# **Consultee Comments for Planning Application PL/2022/00294/MINFHO**

Application Number: PL/2022/00294/MINFHO

Address: 35 Oakley Fen End Solihull CV8 1QE

Proposal: Single storey front, side and rear wrap around extension to replace existing store and shed. Extension of front canopy.

Drawing Title
Planning / Existing & Proposed
Joint Floor Plans

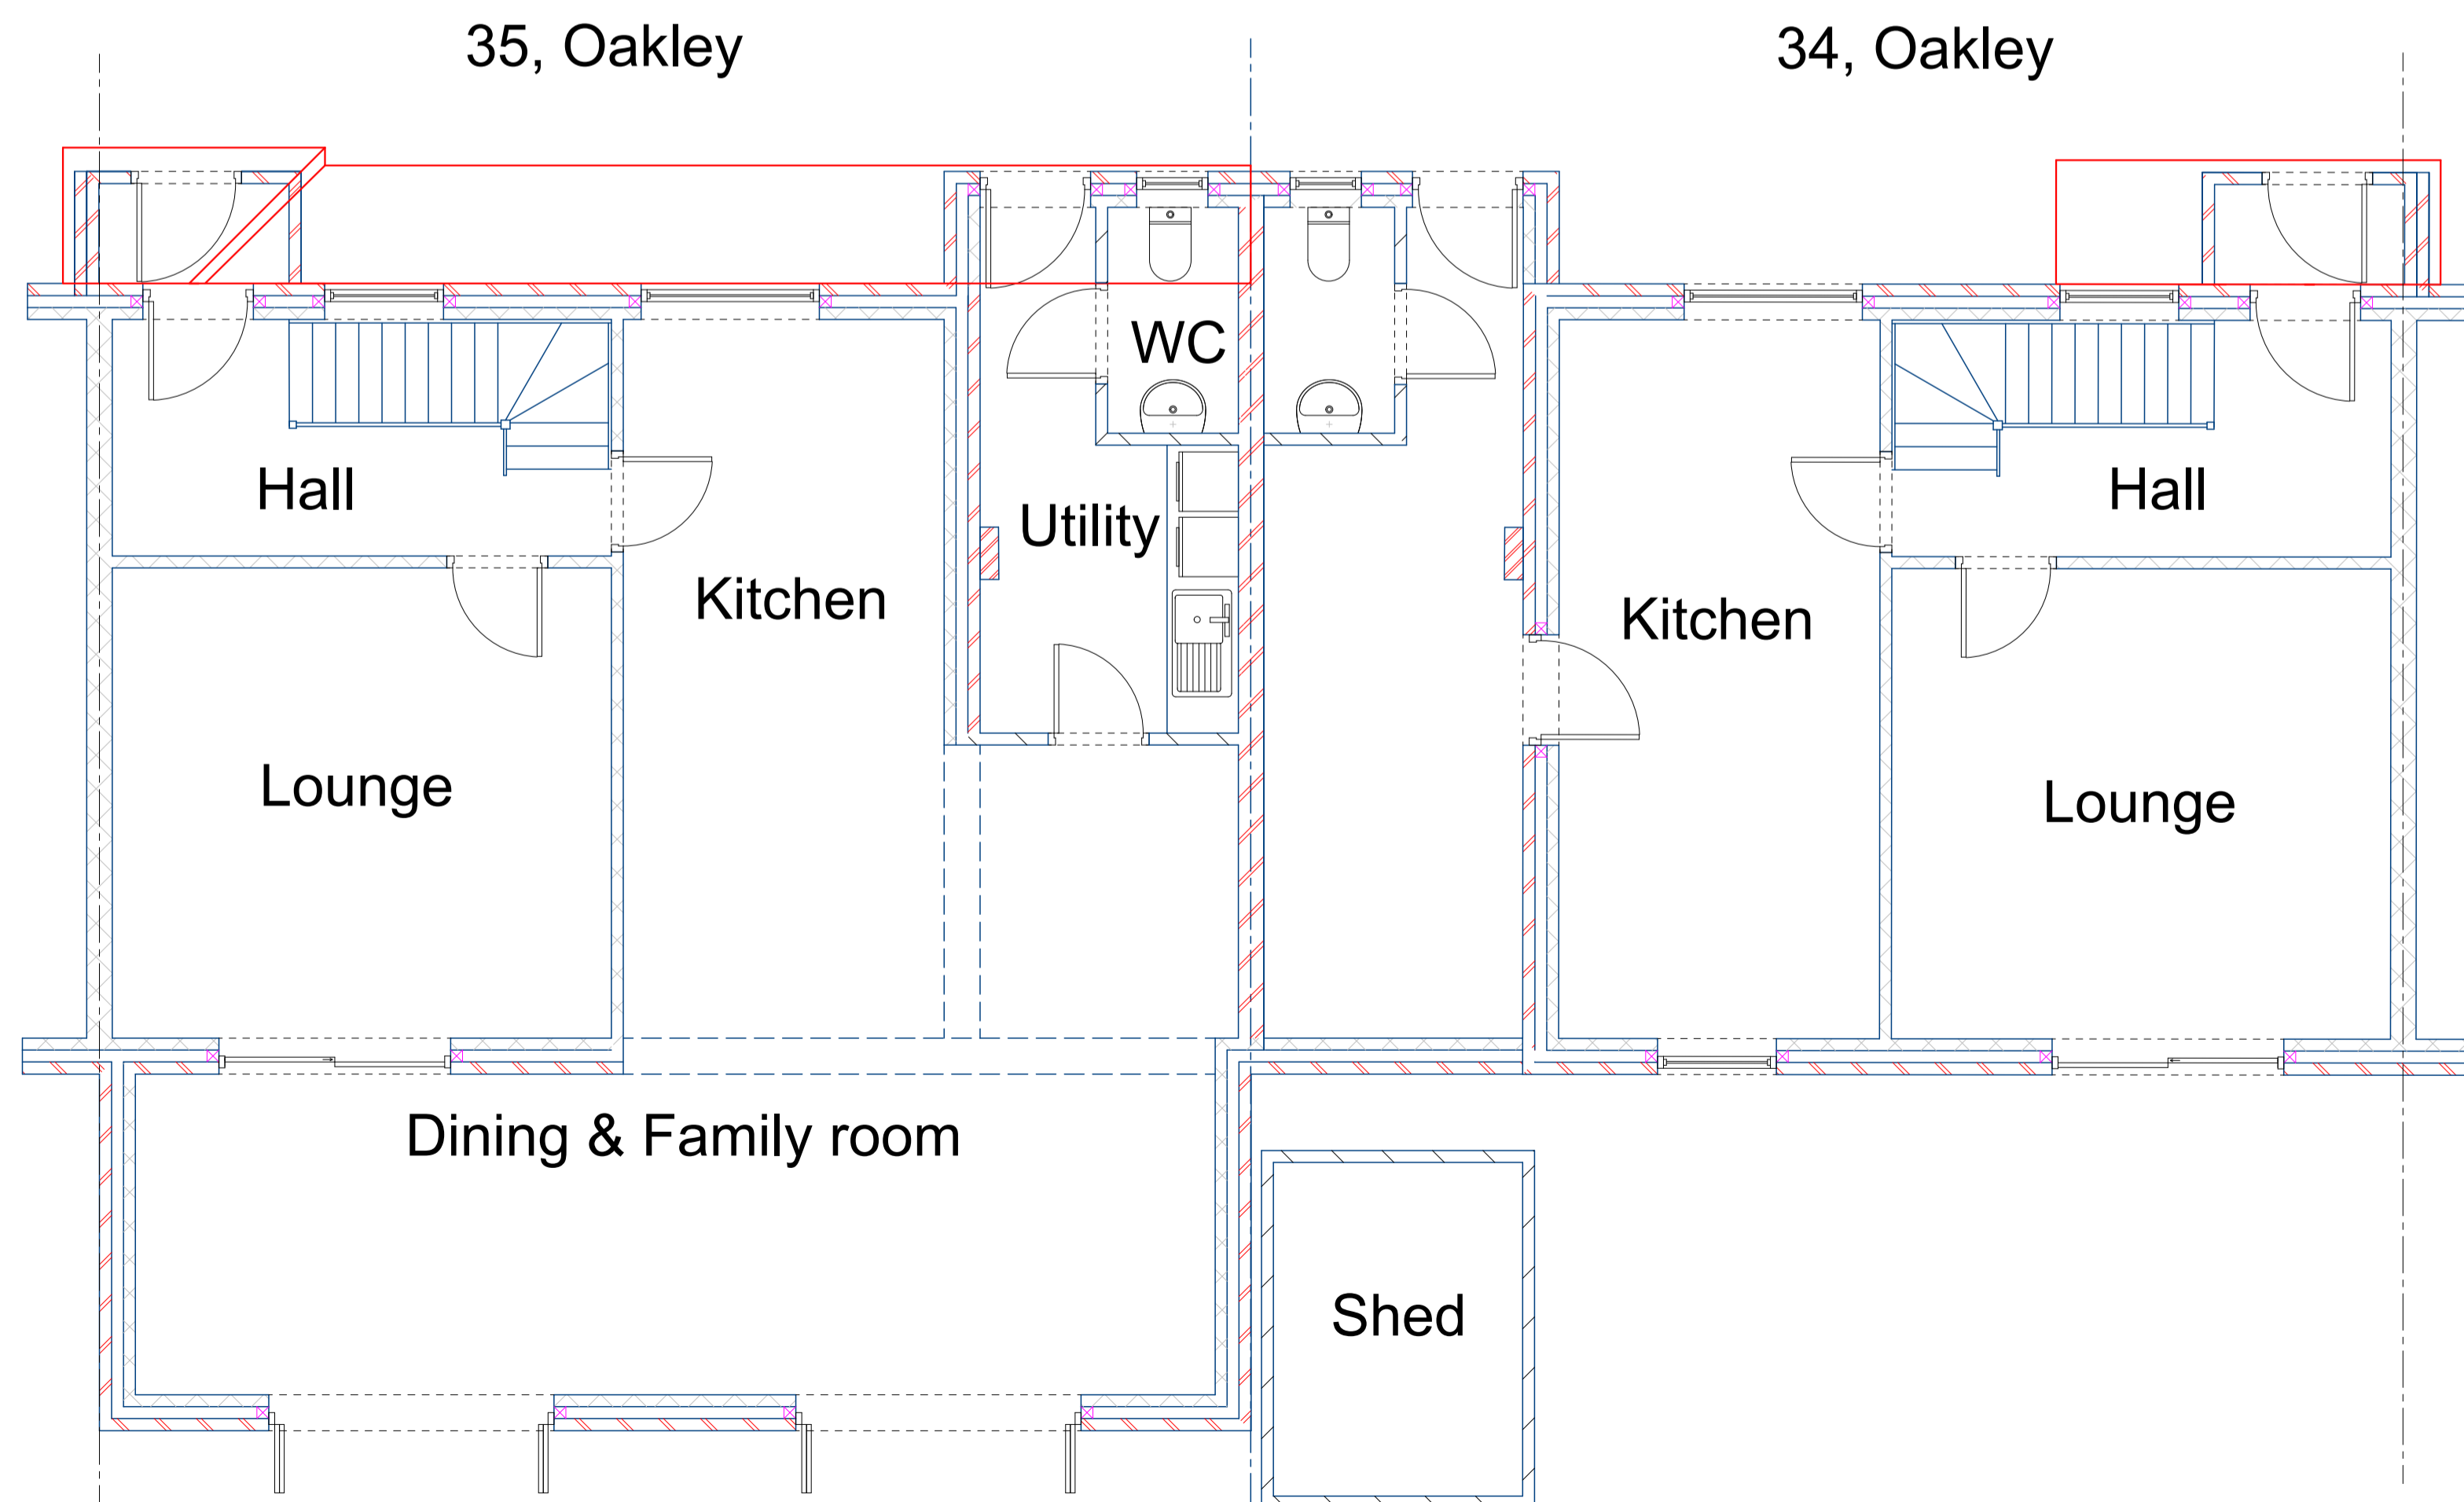
i) drawings suggested 34 Oakley would have a mirror version but no application has been received.

ii) If both proceed there is likely to be a terracing effect.
